HYNLONG PTY LIMITED

26 February, 2015

**Re: Orica Southlands Remediation and Warehouse Project 06_191 Mod 2 amendment to
warehouse layout**

Figure 7: Proposed Subdivision and Easement Plan

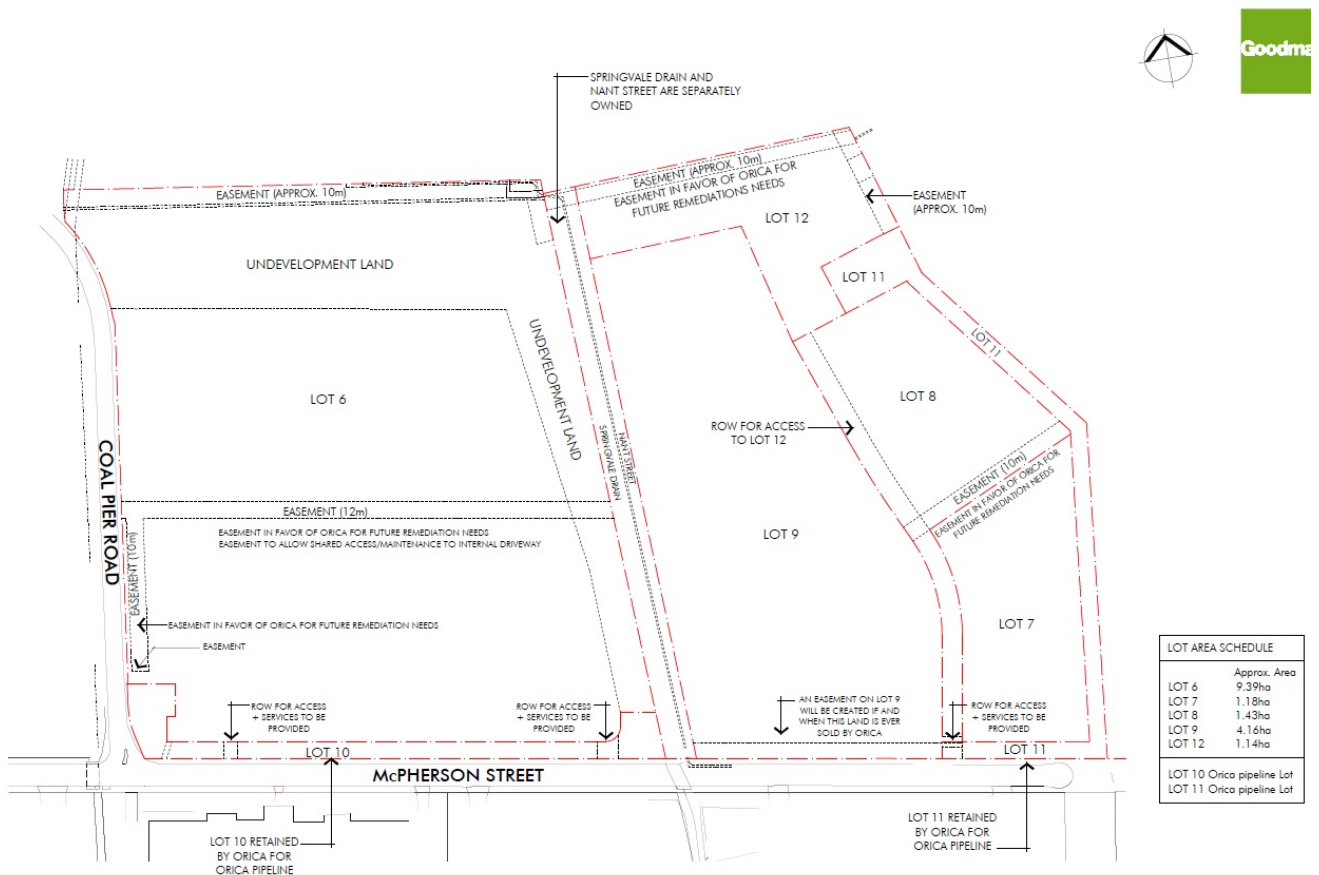
- We note the response under the heading "Subdivision Plan" on Page 13 of the applicant's (Goodman) Response to Referrals/Department of Planning Queries document which states "Any previous subdivision drawings are replaced by Drawing No: 4244_SK053 dated 5 November 2014 prepared by Nettletontribe". Accordingly, we submit that **the proposed change to Sch 2/13 on Page 15 of the Environmental Assessment (EA) by UAS (see Page 15 attached) is incorrect and the only change should be to update the plan reference to the above drawing** so that a clear and complete subdivision plan is referenced for all areas of the land (Areas 1, 2 & 3).

- Page 15 of the EA by UAS – **the second reference to Condition Sch 2/14 is incorrect and should read Sch 3/8A.** (See Page 15 attached).
- **The proposed amendment to Sch 3/8A is incorrect and should reference Lots 6 and 9 (as shown on Drawing No. 4244_SK053 dated 5 November 2014 prepared by Nettletontribe) and not Lot 1.** There is no Lot 1 in the proposed subdivision. (The Lot Area Schedule contains an out of date reference to Lot 1 which is in the original and first modification plans). Lot 9 has been overlooked as this area was originally to be developed with warehouses until detailed flood analysis was carried out. Lot 9 is to be created as a flood detention basin for the whole of Southlands. (See attached Proposed Subdivision Plan).

- **The restriction on use referred to in Sch 3/8A should only be able to be varied by Botany Council and/or the Department of Planning and not the applicant (Orica/Goodman).** It is **deeply concerning** that Lot 6 has already been created (now known as Lot 102 DP 1189375) with inadequate protection of the flood detention areas of the Lot because of the accompanying 88B instrument can be varied at the sole discretion of the applicant (copy attached).
